TR010065 – A46 Newark Bypass Project

Canal & River Trust Comments on responses to ExQ1

Waterway: River Trent

DRAWING TITLE
 Figure 2.4
 Locations of Temporary Works Areas Required
 During Construction
 Sheet: 3 of 4

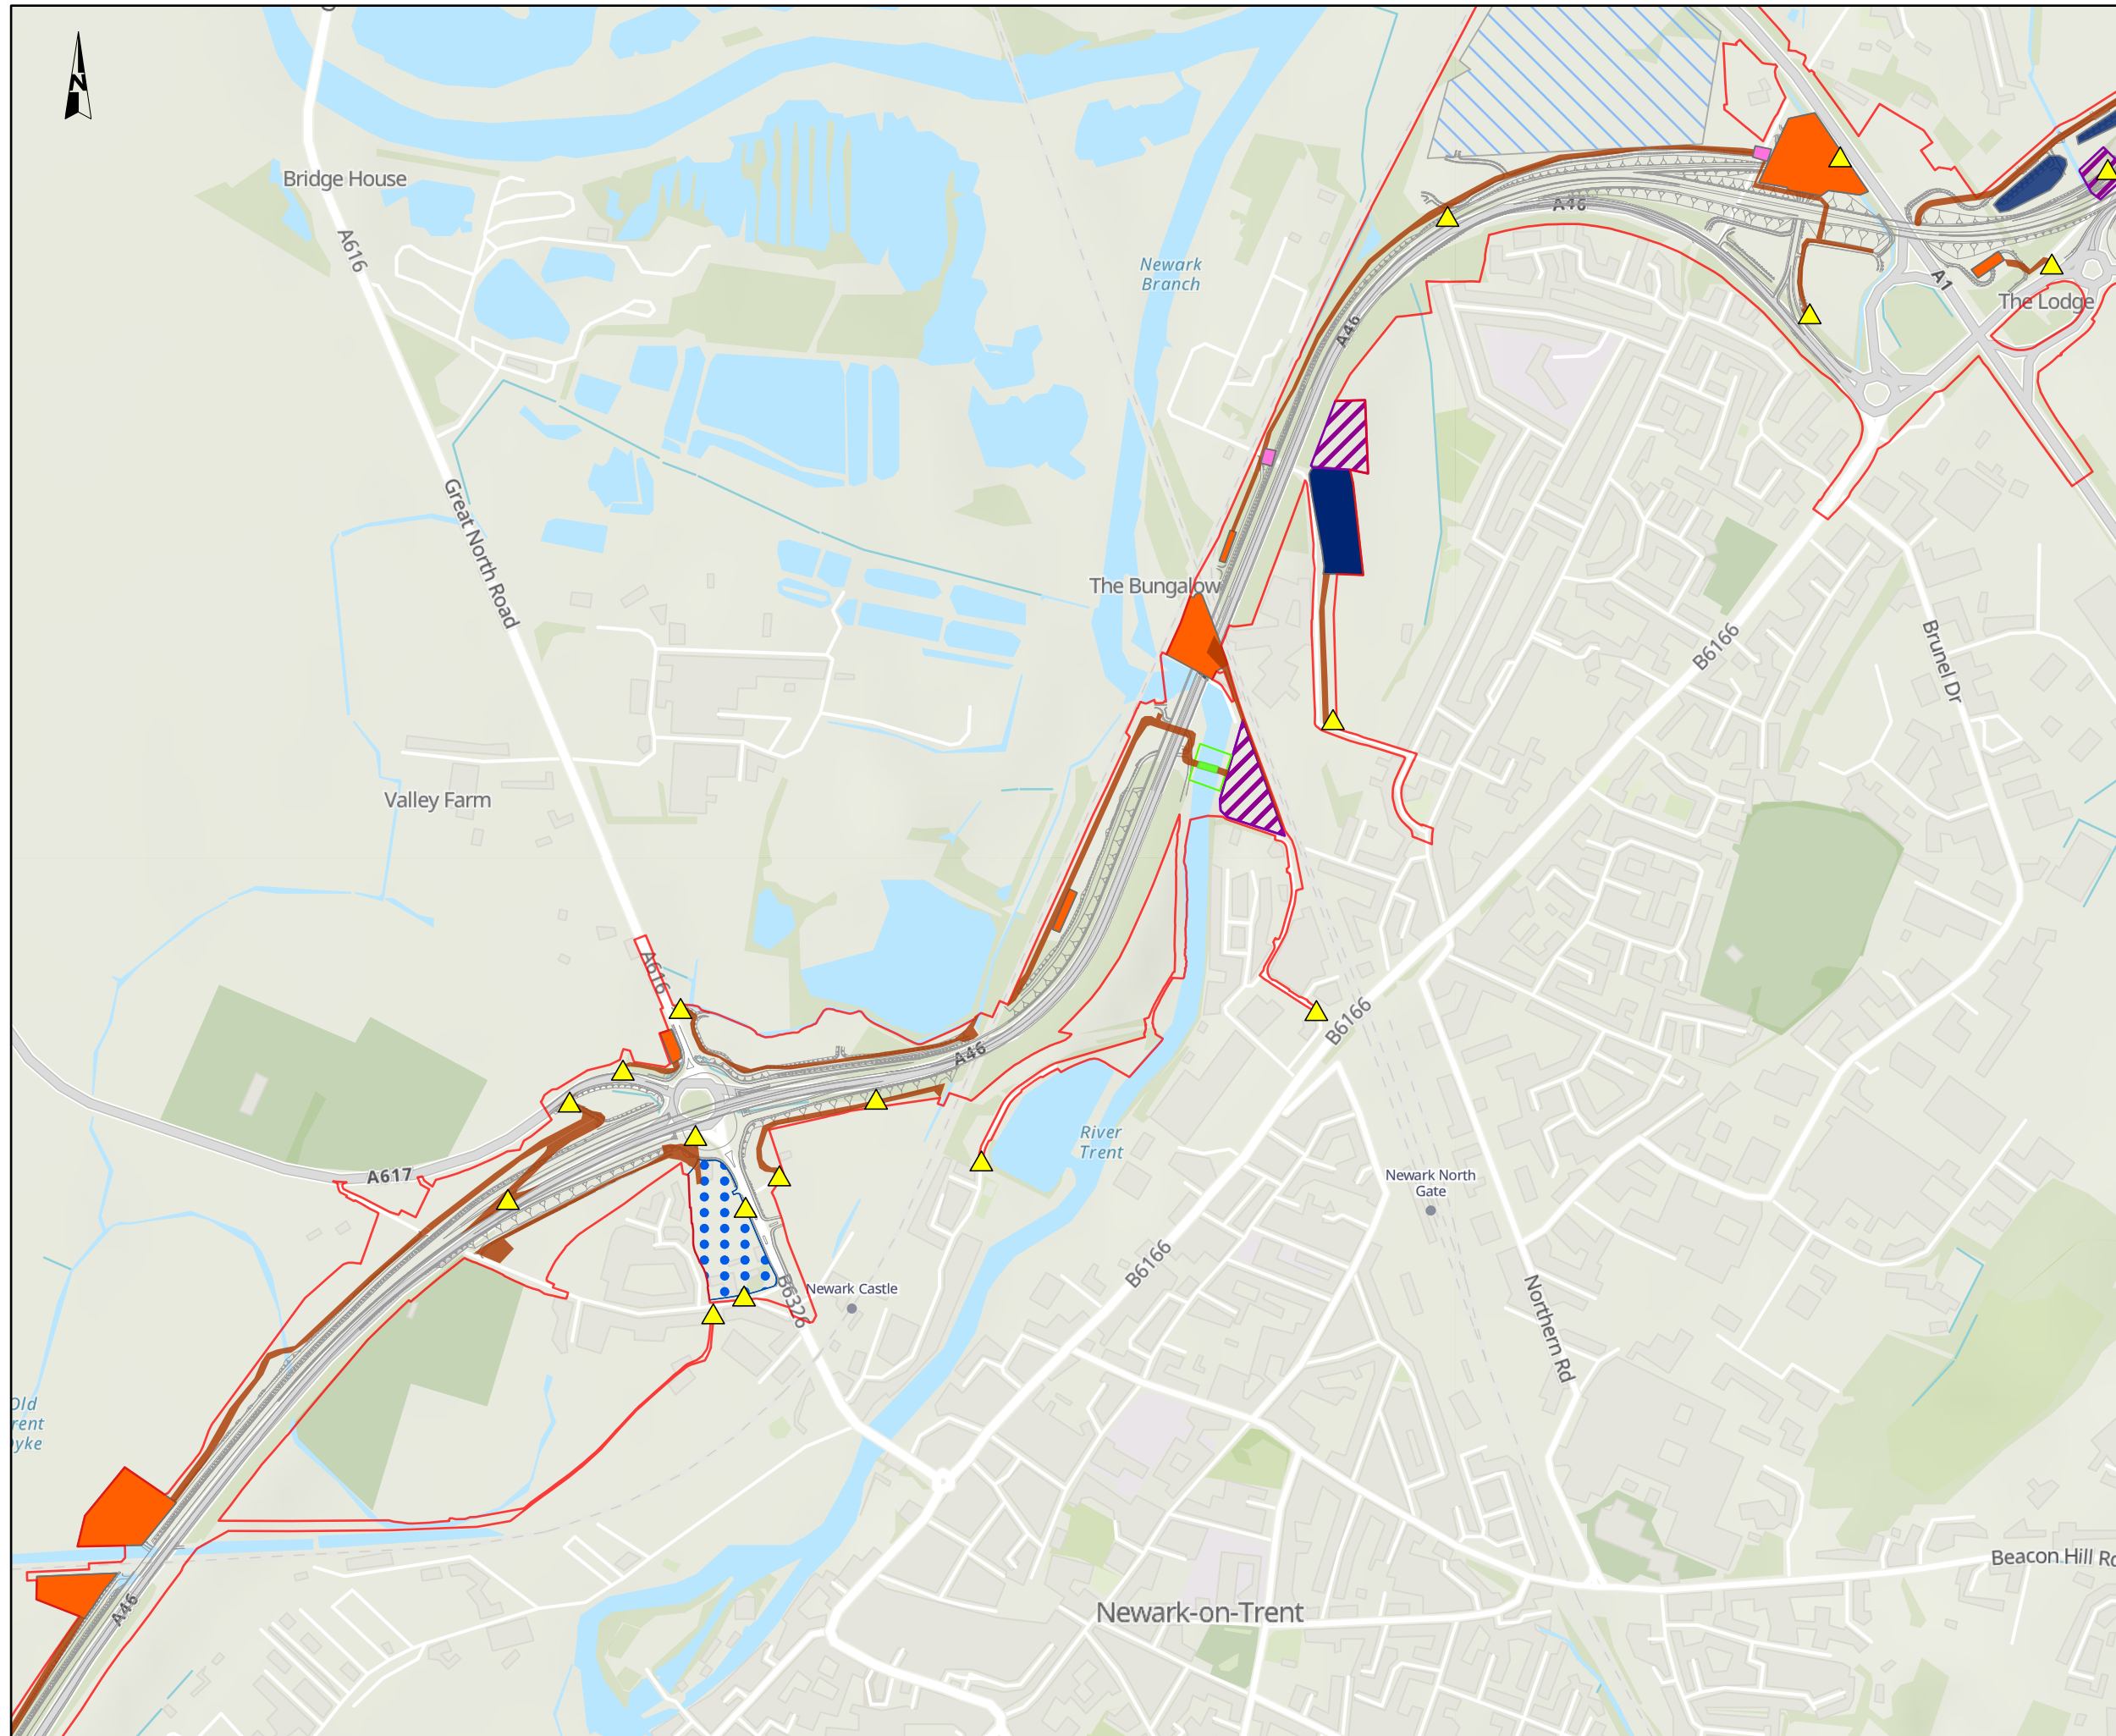
The applicant has stated that it confirms the temporary bridge over the River Trent, shown as Work No. 63 on Sheet 4 of the Works Plans [A5-005] will provide the minimum clearance required by the Trust for navigation. For the avoidance of doubt, to allow for the safe passage of craft below the temporary bridge, a 5m clearance to the River Trent is required. This should be measured from the crest of Nether weir (the first weir downstream of the current A46 road bridge). We consider it important that the final DCO does not include provisions that would allow for a deviation from the description that could reduce this clearance below 5m.
